**KIRKLEES METROPOLITAN COUNCIL
INVESTMENT & REGENERATION SERVICE**

Reference No: 2018/62/92347/W

Site Address: 92, New North Road, Edgerton, Huddersfield, HD1 5QP

Description: Partial demolition and change of use of ground and lower ground floors to offices (B1) and external alterations (within a Conservation Area)

PLANS AS EXISTING

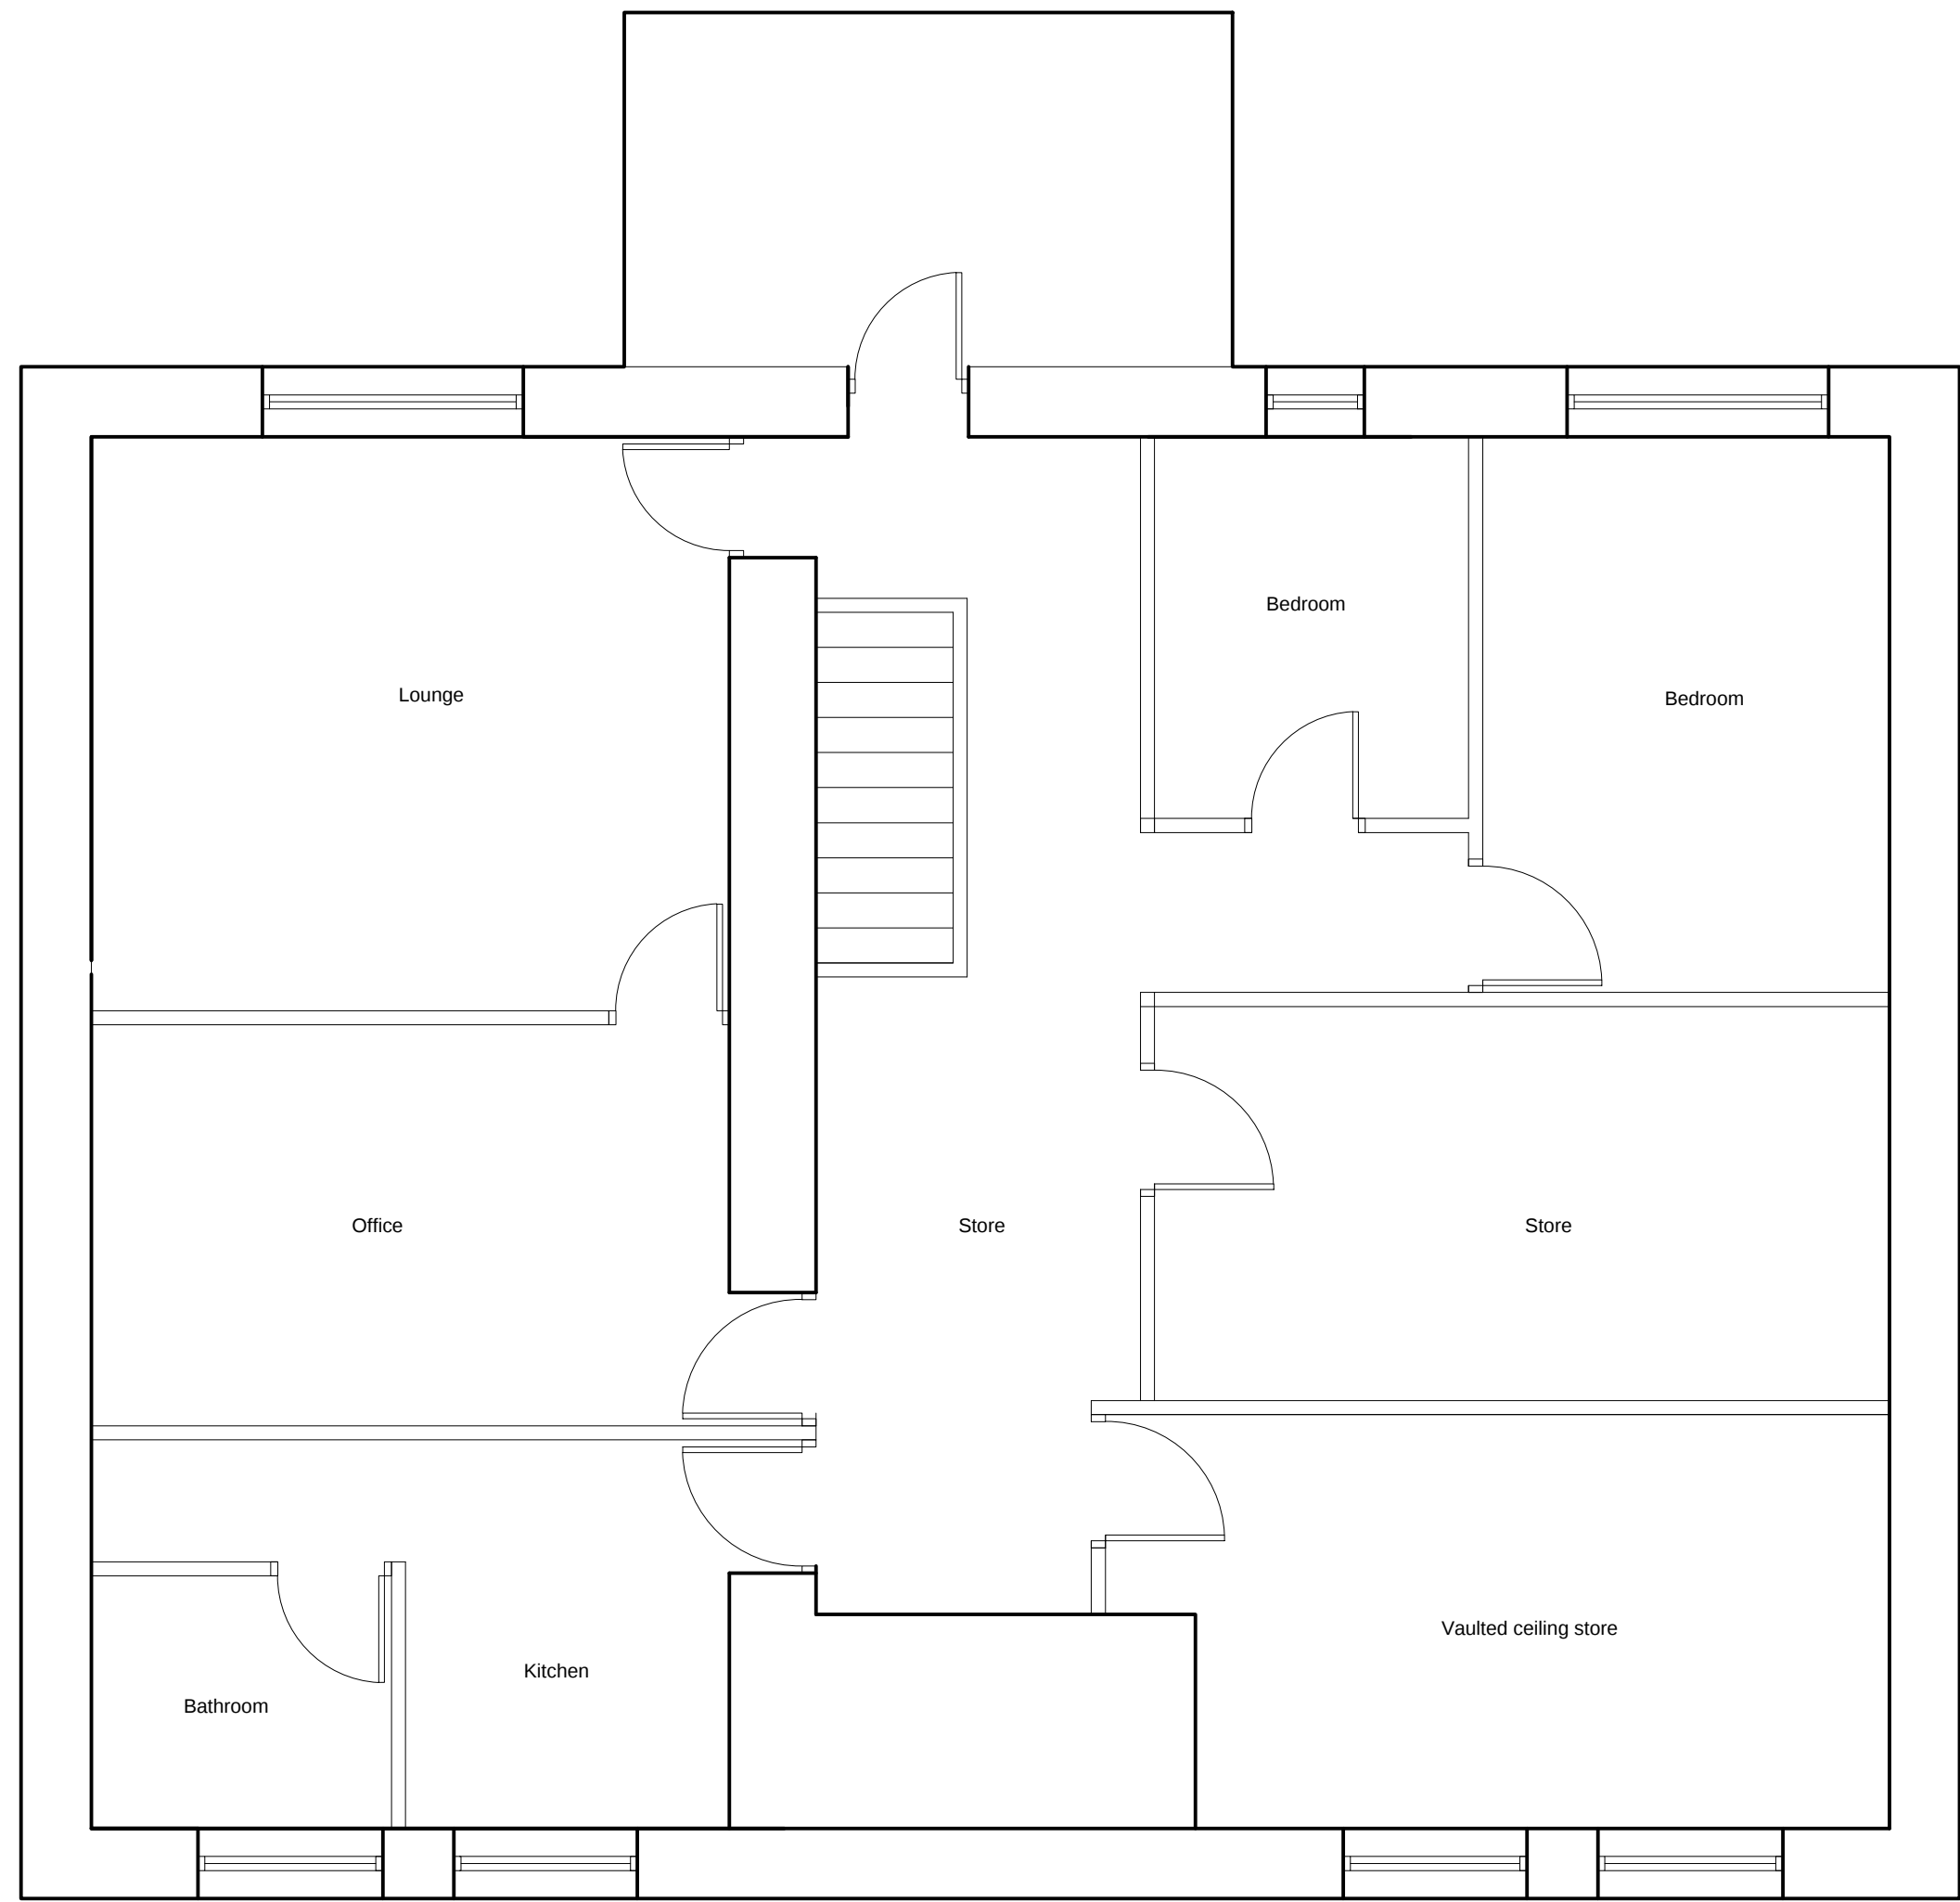
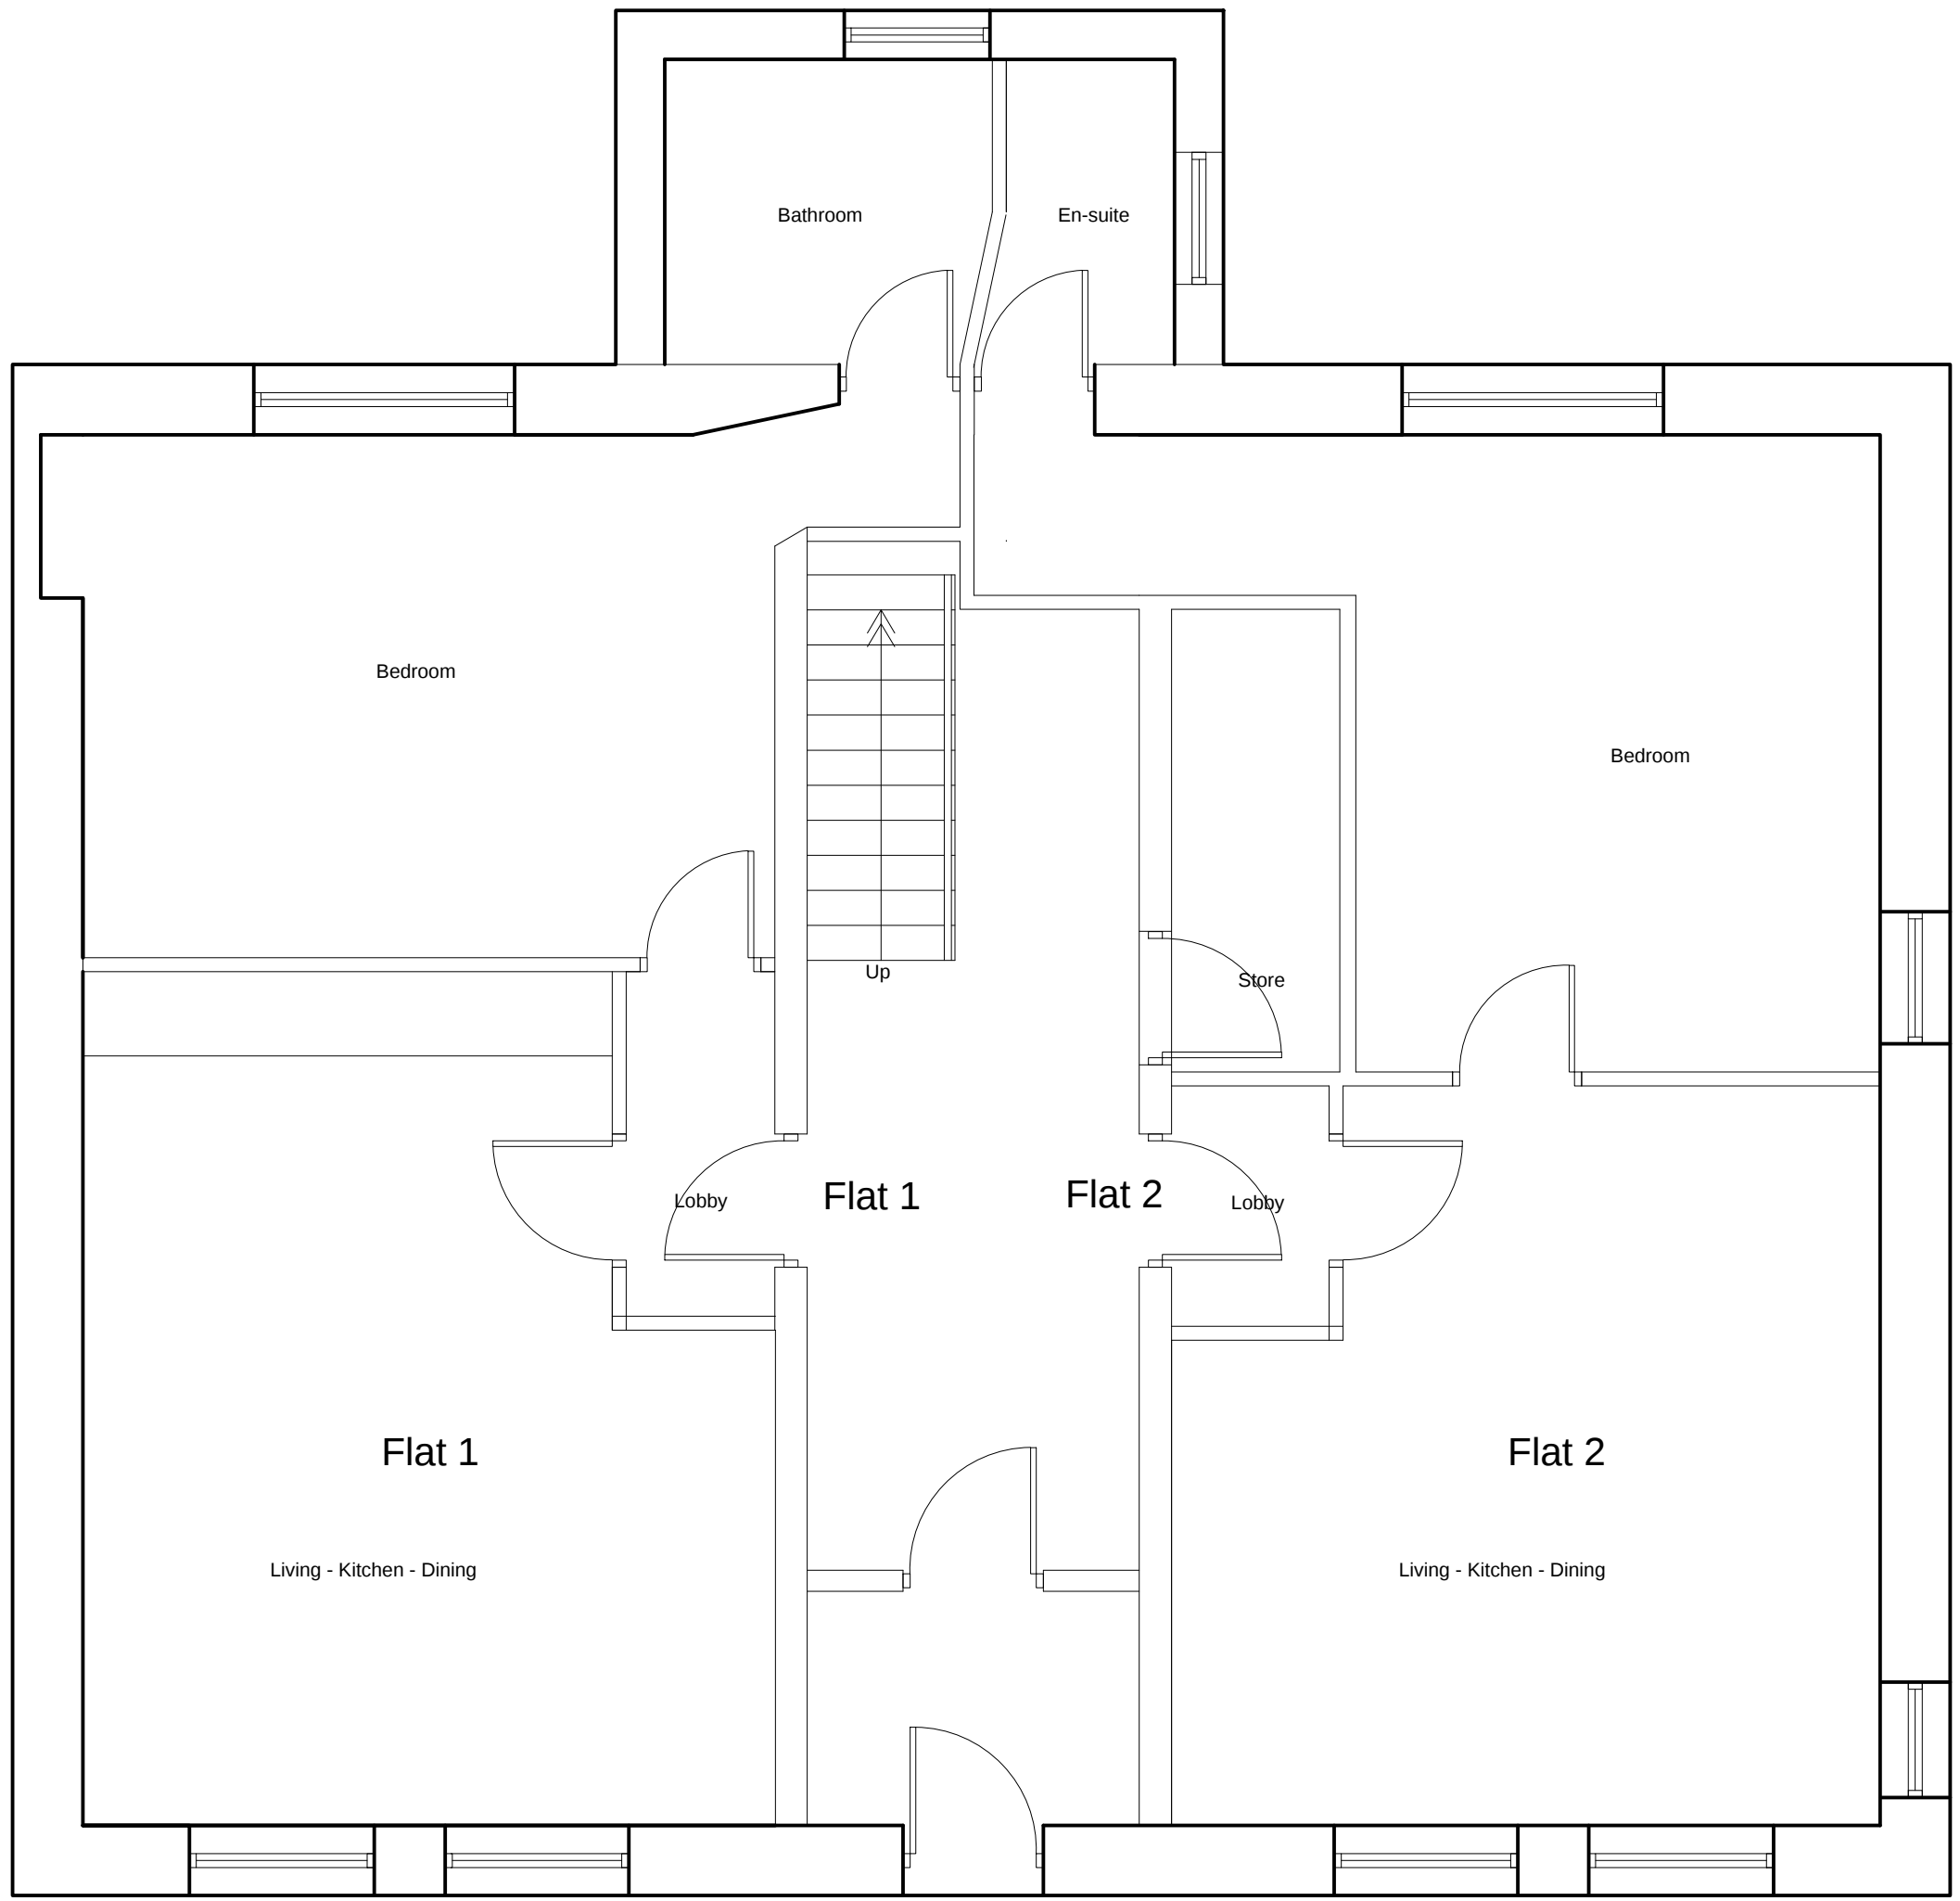
The alterations to the rear of the property to provide a separate rear access to the apartments on the upper floors. As the existing balcony is relatively low, a new handrail will be installed above the existing to ensure compliance with building regulations. This rail (and proposed door) should be painted black to match the existing. Historic fabric will be restored and retained with minimal intervention.

3. The new handrail and balustrade and any new external door installed to the upper ground floor rear entrance shall be painted black before the new upper ground floor office space is first brought into use and thereafter retained as such.

DRAWING DESCRIPTION
Car Park - Swept Paths
1 of 2

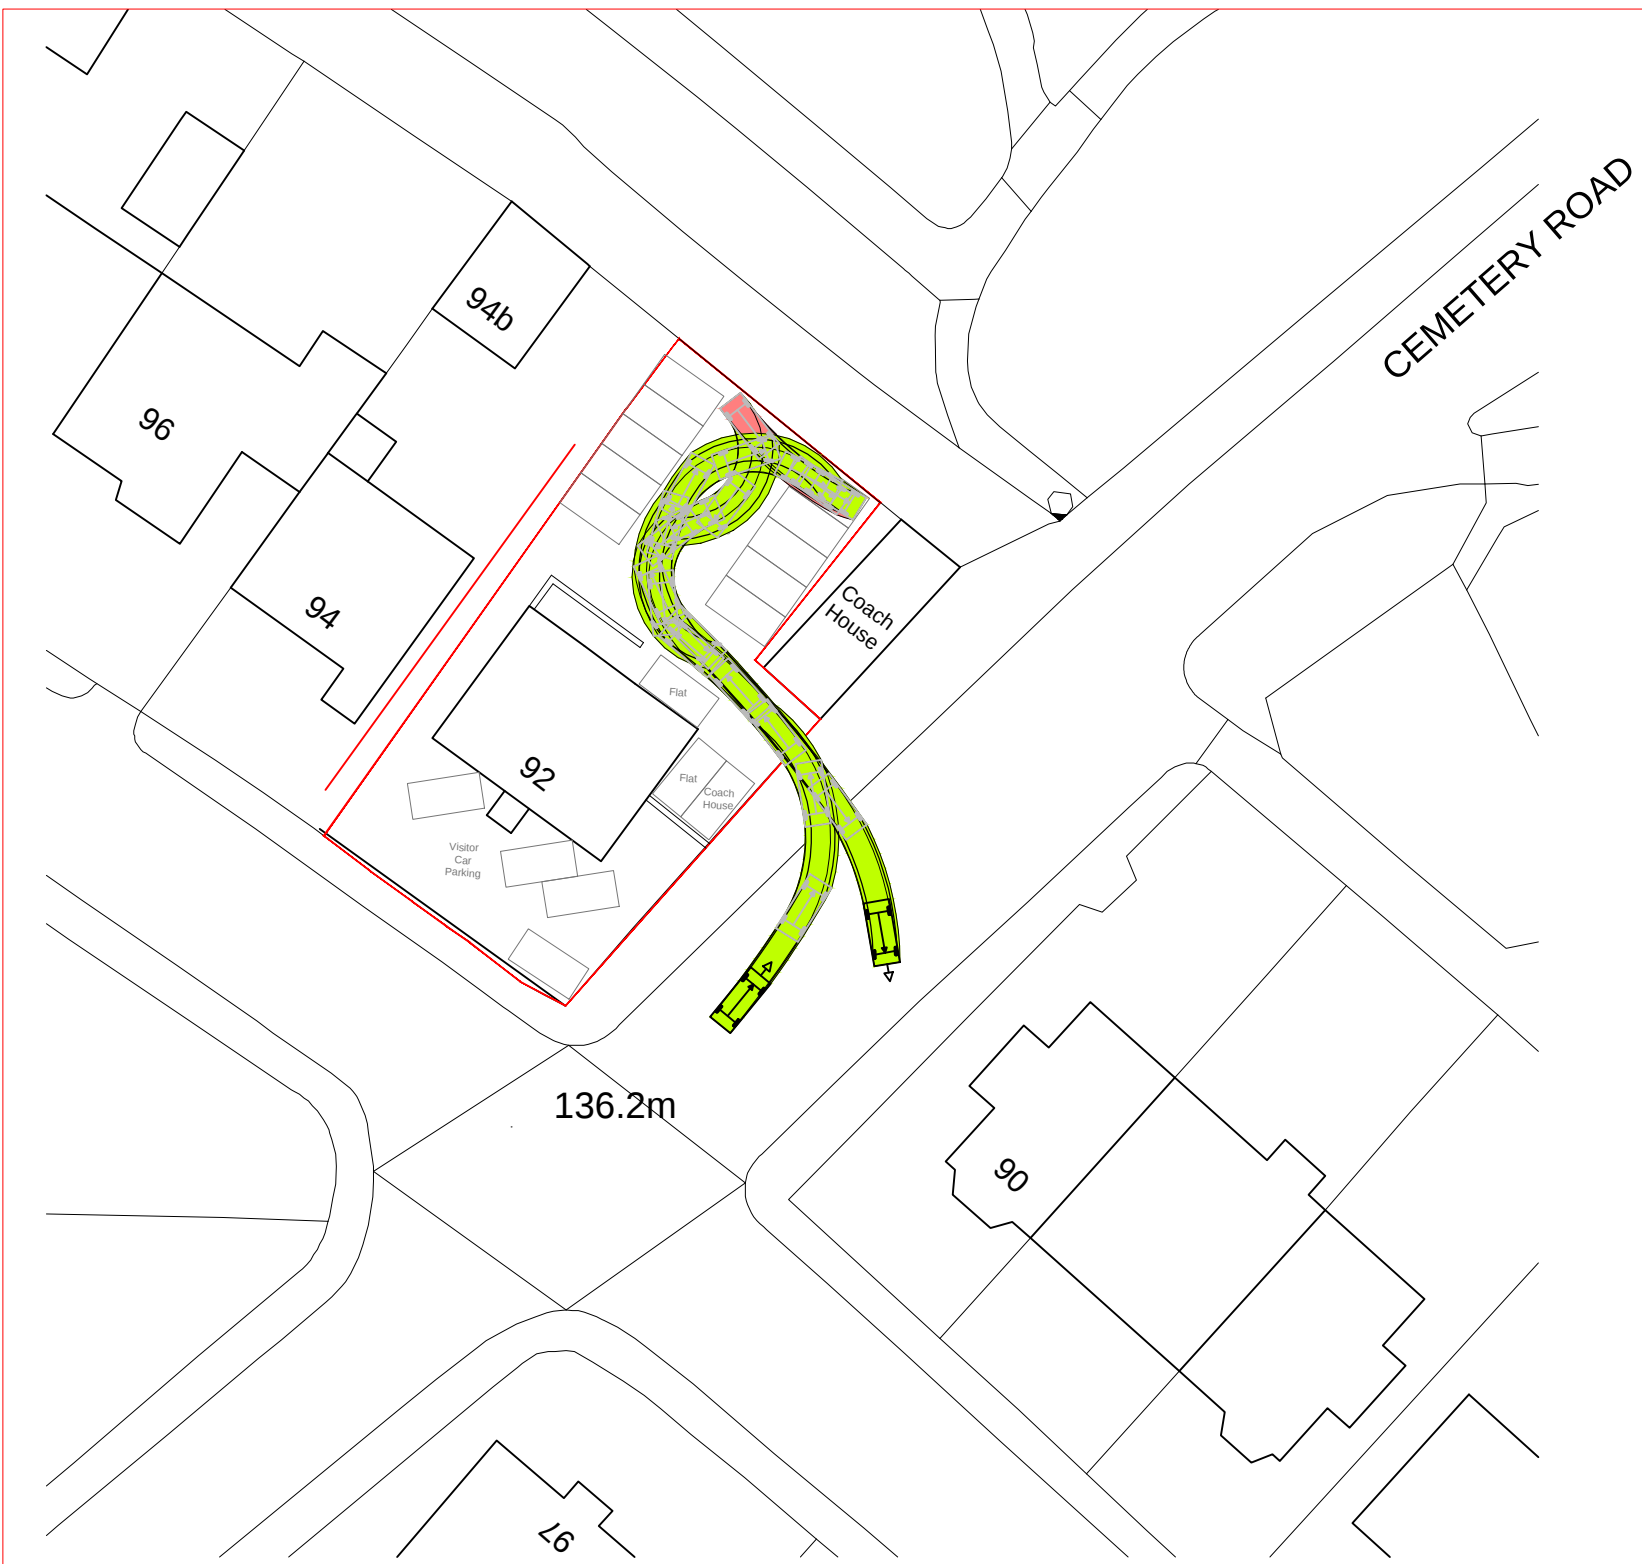
After a number of revisions, a set of plans has been submitted showing the layout of parking provision and detailed swept paths within the site. The 9 proposed staff parking spaces are just within acceptable dimensions (4.8m long and 2.4m wide) and can be accessed safely (the two rows of spaces would be 6m apart which is the minimum distance to allow sufficient room for manoeuvring). The visitor parking spaces (3 in total) are at the front and the swept path drawing demonstrates that they can be safely accessed using the land within the application site only and that users would be able to turn.

Parking spaces: There is not enough space to pull a car into each space, the 7 parking spaces encroach on to land owned by the adjacent property, only one car would fit at the side without displacing the existing waste storage bins, 2.5 by 5.0m is now considered too small, adjacent property (94 and 94b) would struggle to pull out past the central spaces;

Response: The original layout was very awkward in that the 7 spaces at the rear would probably not have had room to turn, and spaces 8-9 (in the middle of the rear car park) would have impeded access to the rearmost parking spaces, allowing only 5m for them to manoeuvre out. The swept path plans, submitted in response to Highway Officer’s concerns, change the layout, allowing more space for manoeuvring, and the final version demonstrates that there is enough room to turn.

Officers are satisfied that there would be no encroachment onto neighbouring land on the final amended layout. The agent has confirmed that all parking spaces would be within the red line boundary. The original layout would have displaced the waste storage bins, which is no longer the case.
